Ecological comments

Planning Application No: 3/2012/0623

Proposals: **Outline application with all matters reserved for residential development of 23 dwellings, with access, parking and associated landscaping following demolition of nos. 23 and 25 Old Row**

Location: **Land at 23-25 Old Row, Barrow, Clitheroe**

PROPOSED SITE LAYOUT

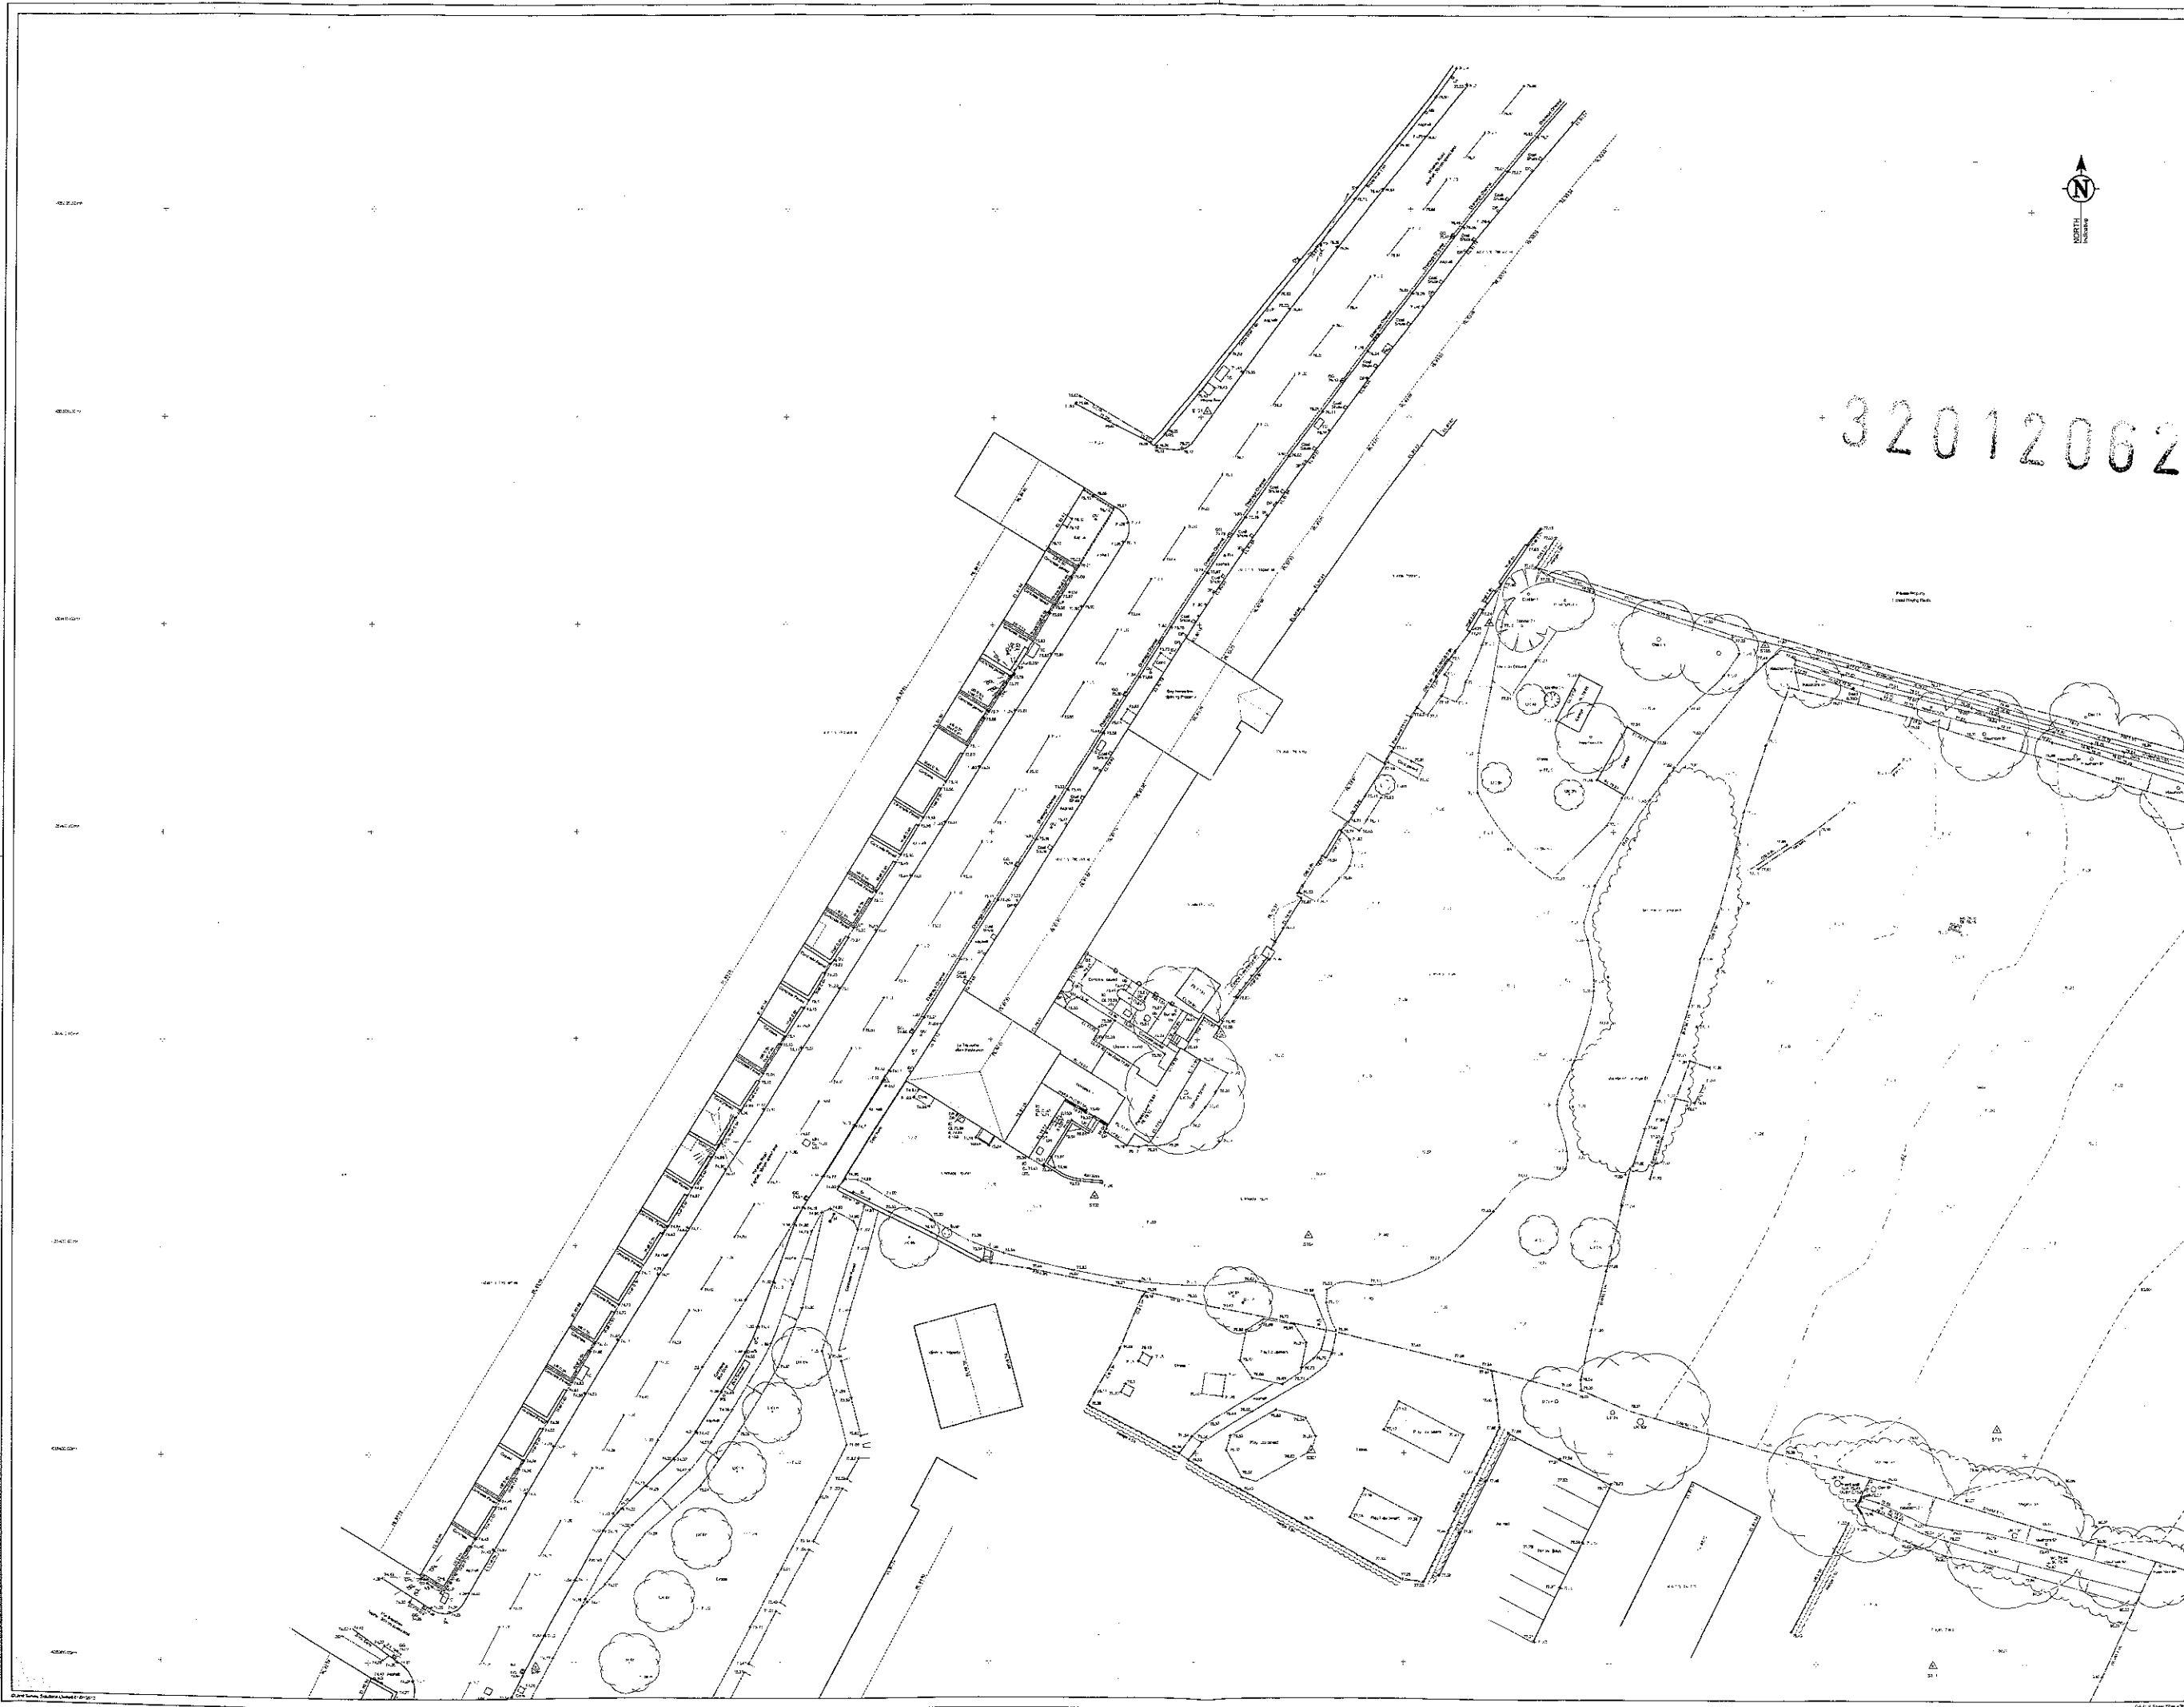
The Ecological Consultant recommends creation/enhancement of species rich hedgerows around the perimeter of the development and planting of native trees and shrubs within the site (para 4.3). In addition the indicative layout plan shows a proposed 5m wide landscaping buffer zone along the eastern boundary of the site. These proposals are appropriate and would provide adequate compensation for the losses. Creation/enhancement of native species rich hedgerows, trees and shrubs along the perimeter of the site would also fulfil the requirements of NPPF to address the integration of new development into the natural environment (NPPF Para 61) and would ensure habitat connectivity/corridors are maintained/enhanced. Appropriate guidance on native species appropriate to the locality is given in Lancashire County Council's Supplementary Planning Guidance on Landscape and Heritage
